12 December 2019

Jason Maslen
School Infrastructure Assessments
Department of Planning & Environment
GPO Box 39
SYDNEY NSW 2001

Re: Submission- New Estella Public School, Wagga Wagga Estella (SSD 9494)

WAGGA WAGGA PS
ESTELLA ROAD, ESTELLA, NSW, 2678
NEW HIGH QUALITY CLASSROOMS PACKAGE 2
COMPOSITE PLAN - LEVEL 00

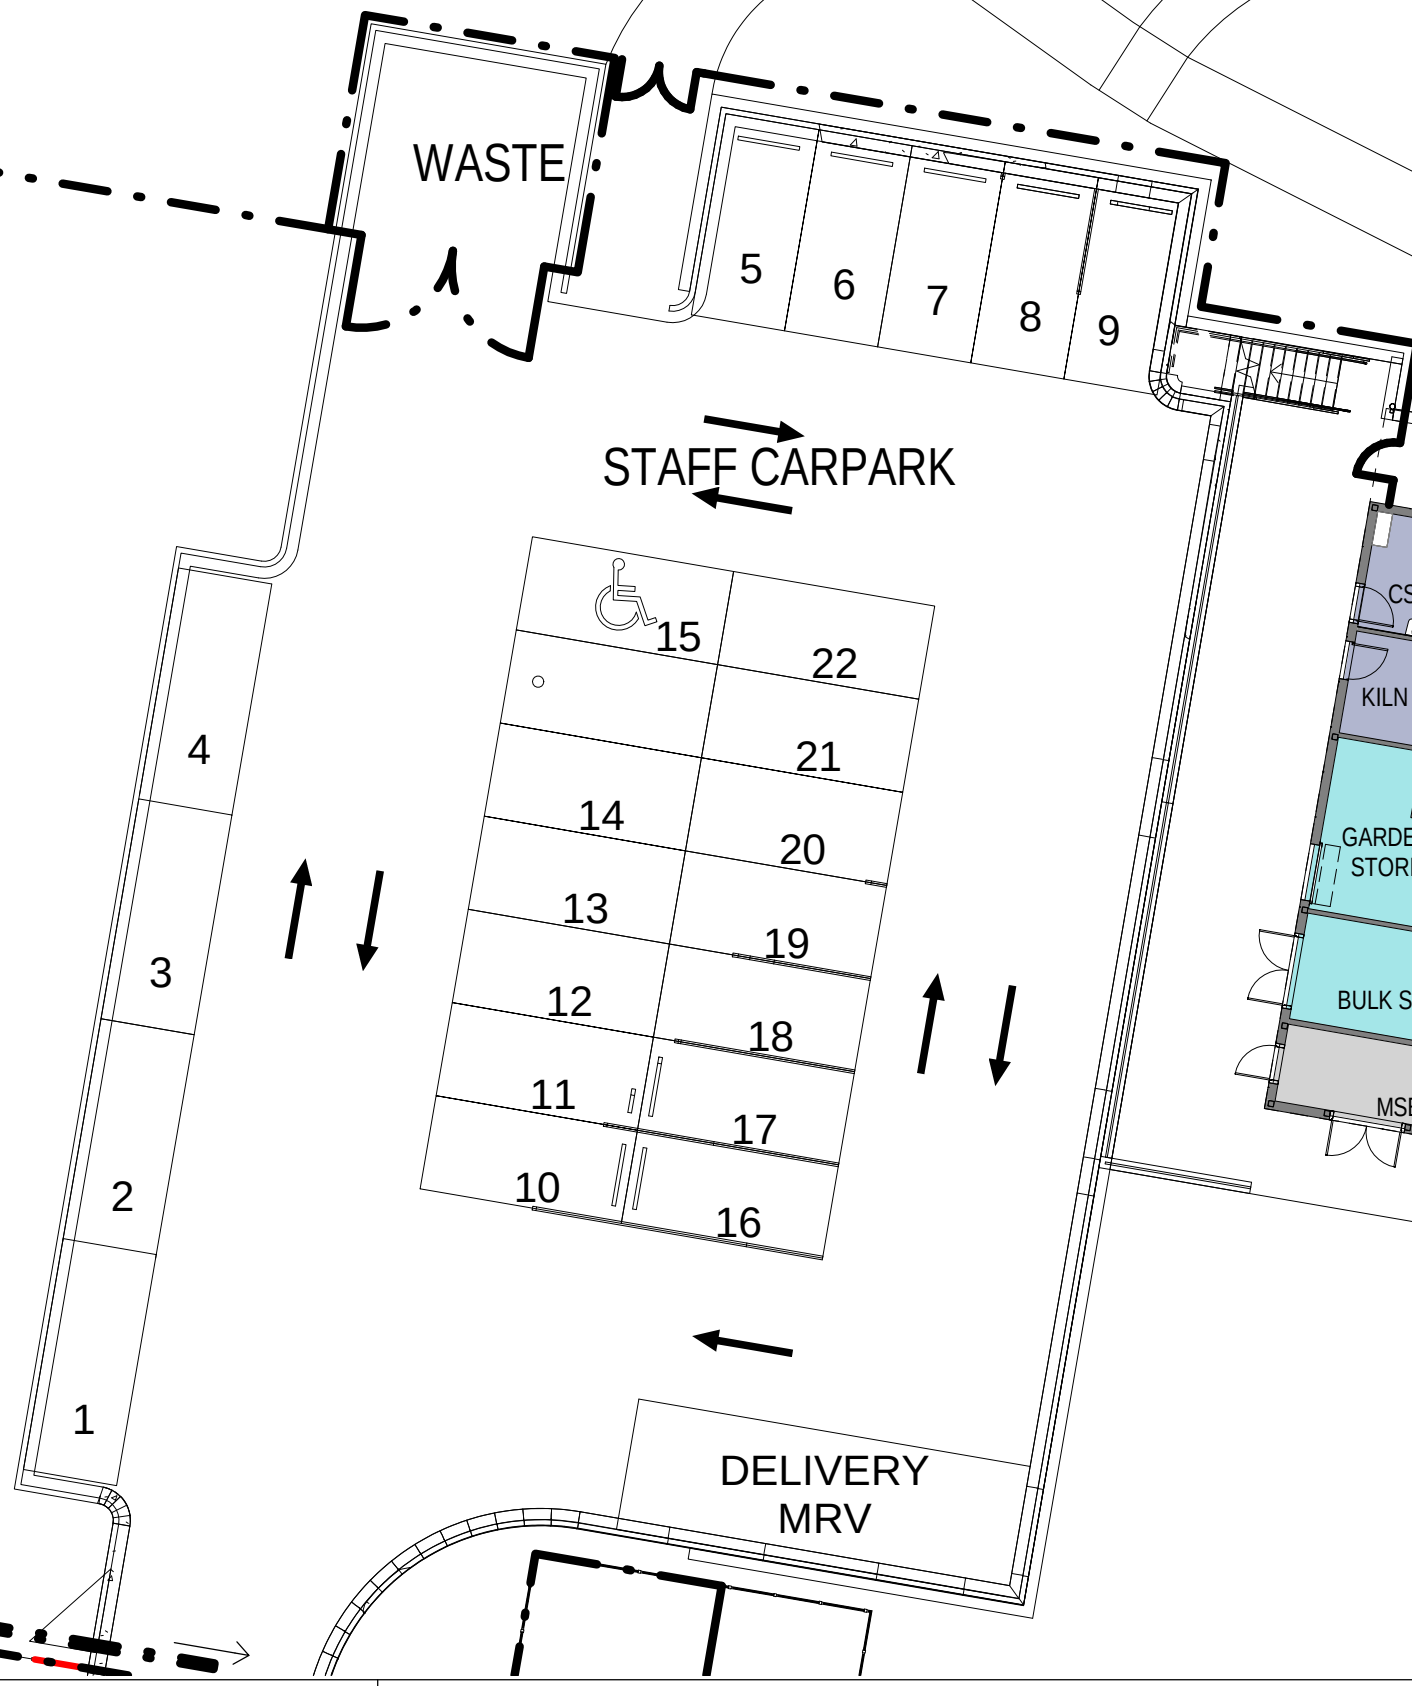
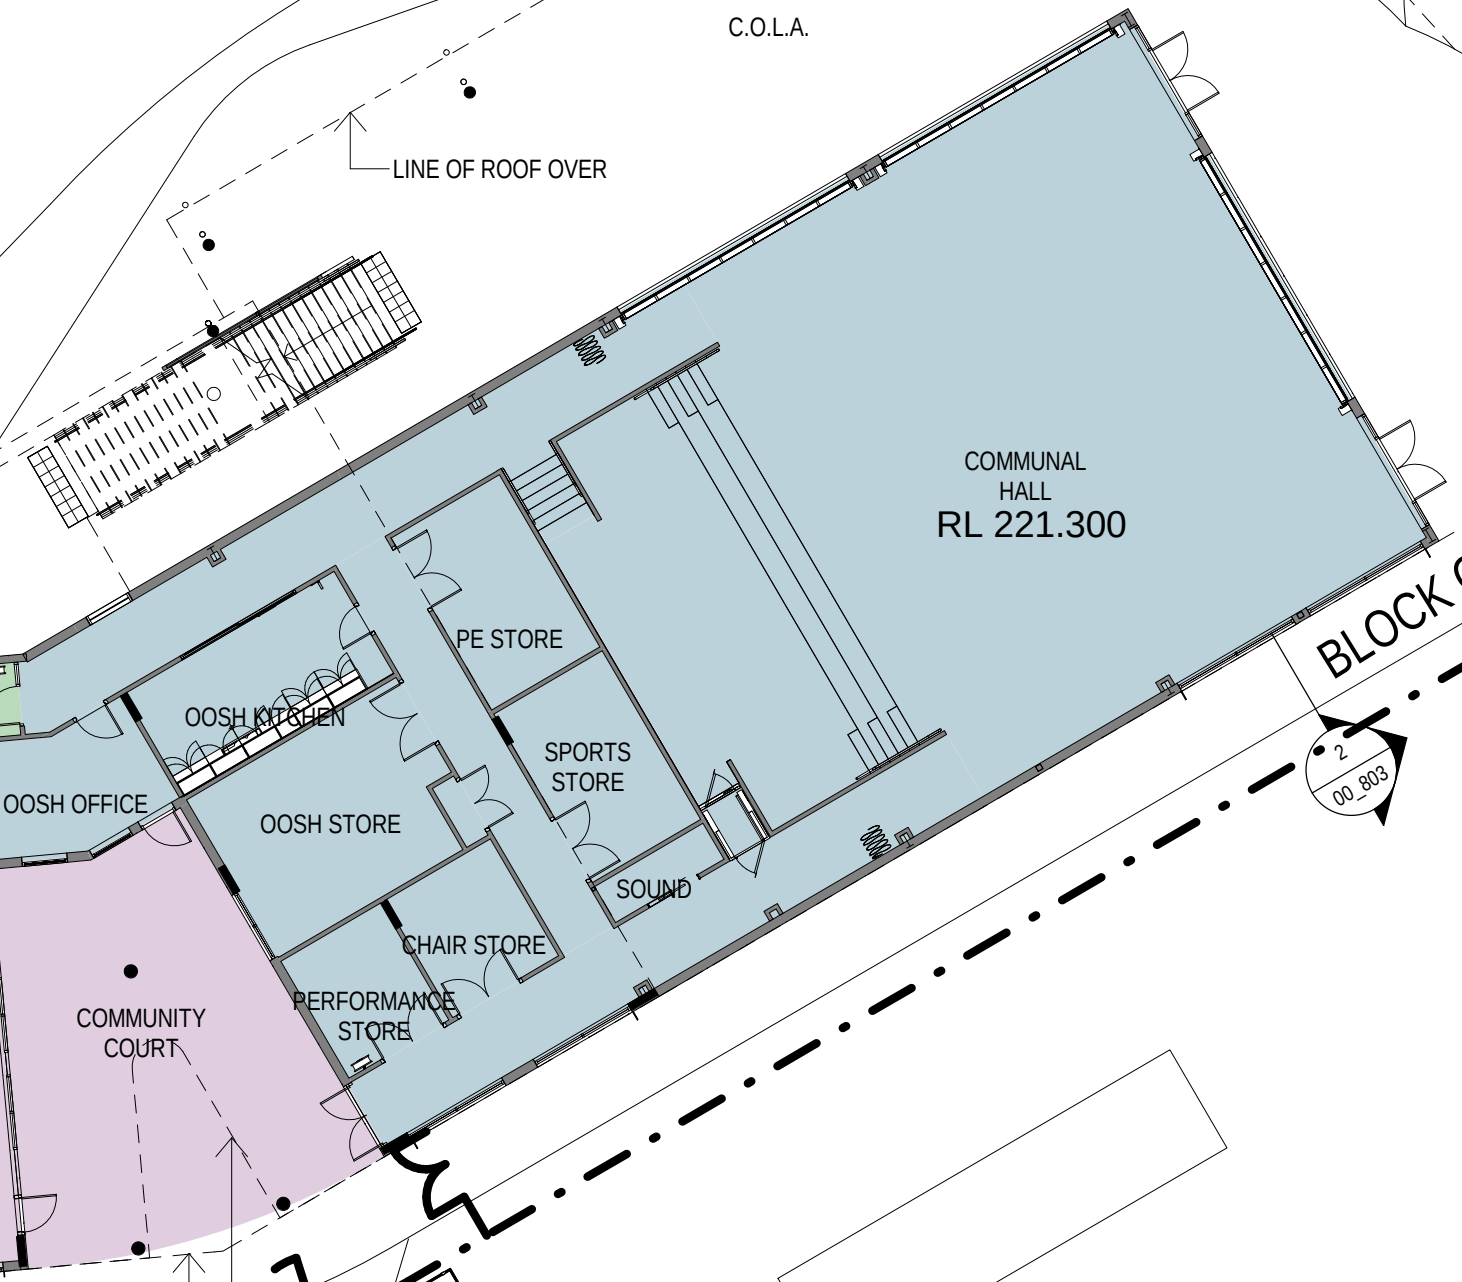
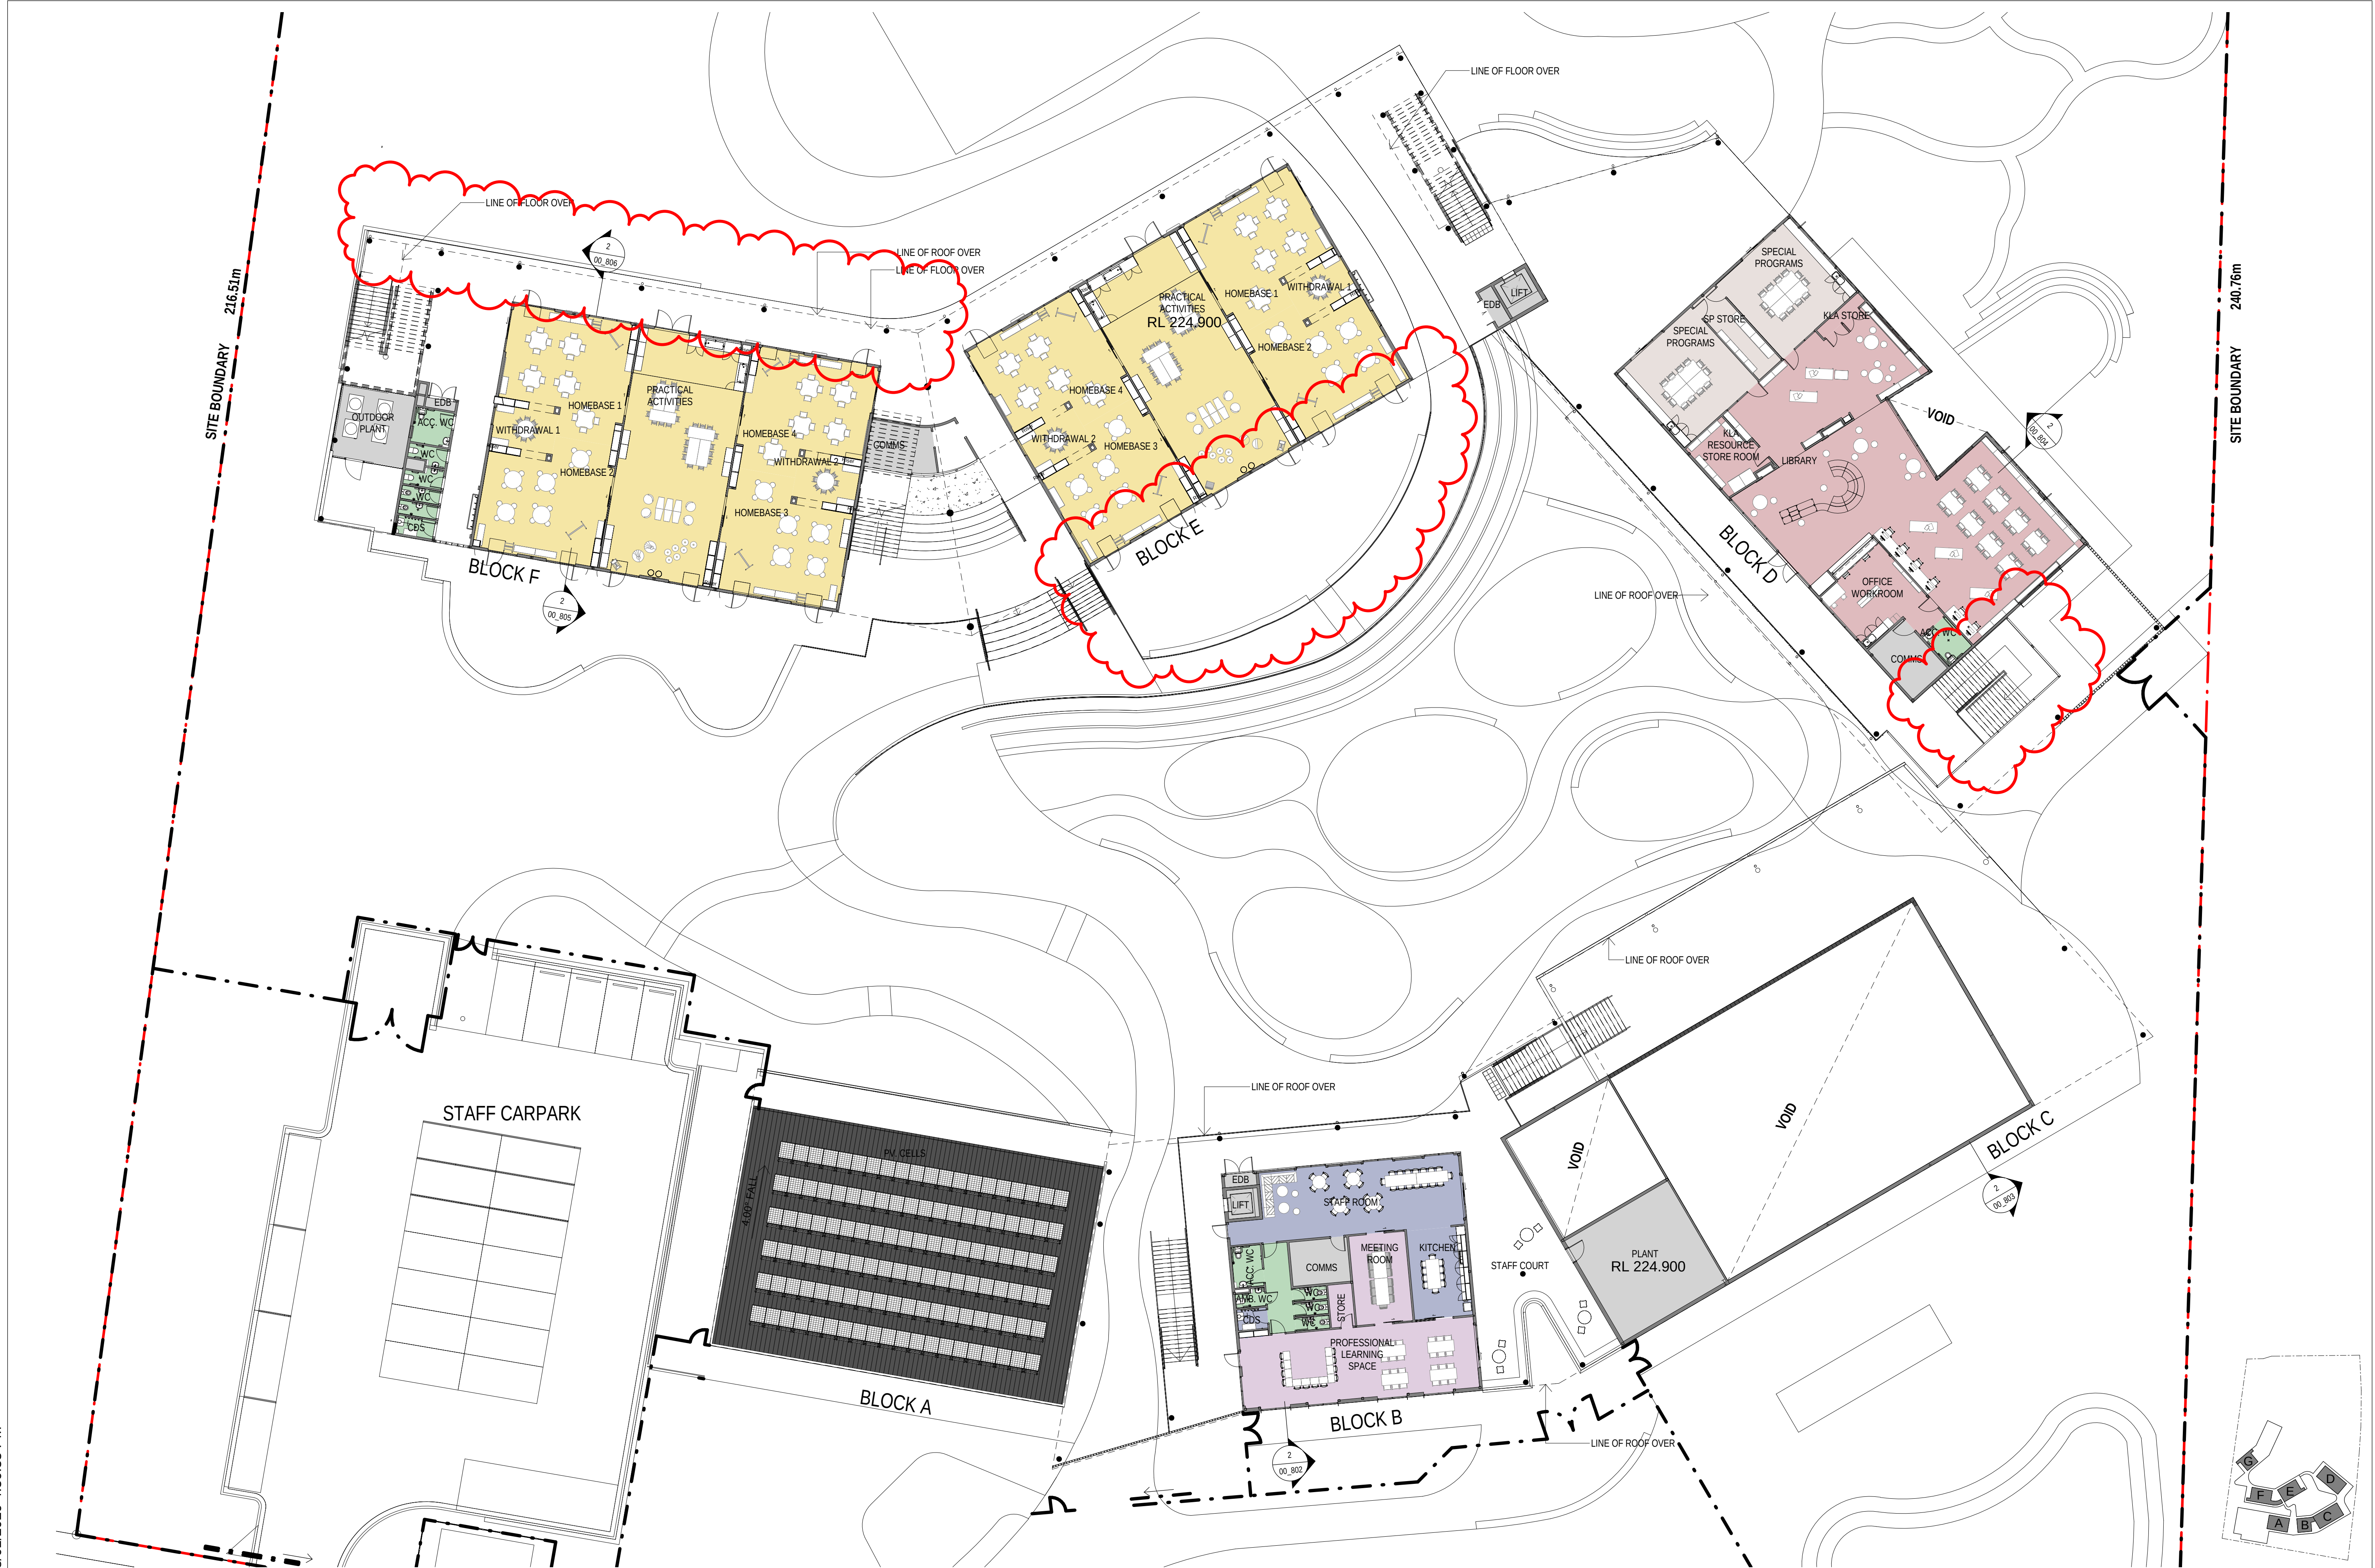
The current design provides a primary entry to the school via Estella Road and additional pedestrian connection to the eastern walkway, providing pedestrian connection to the north and south and to Peter Hastie Oval to the east.

The design lacks linkage to the Yindyamarra Reconciliation site to the west and north-west.

The interface with Estella Road requires some work and more detail is required in relation to the main access, parking facilities, pick-up & drop off area and linkage with pedestrian network as well as road and intersection treatment at Gunn Drive. One of the potential solutions is a shared parking and bus stop zone and on the sporting grounds to the east and Council would like to further discuss these options with the department in more detail.
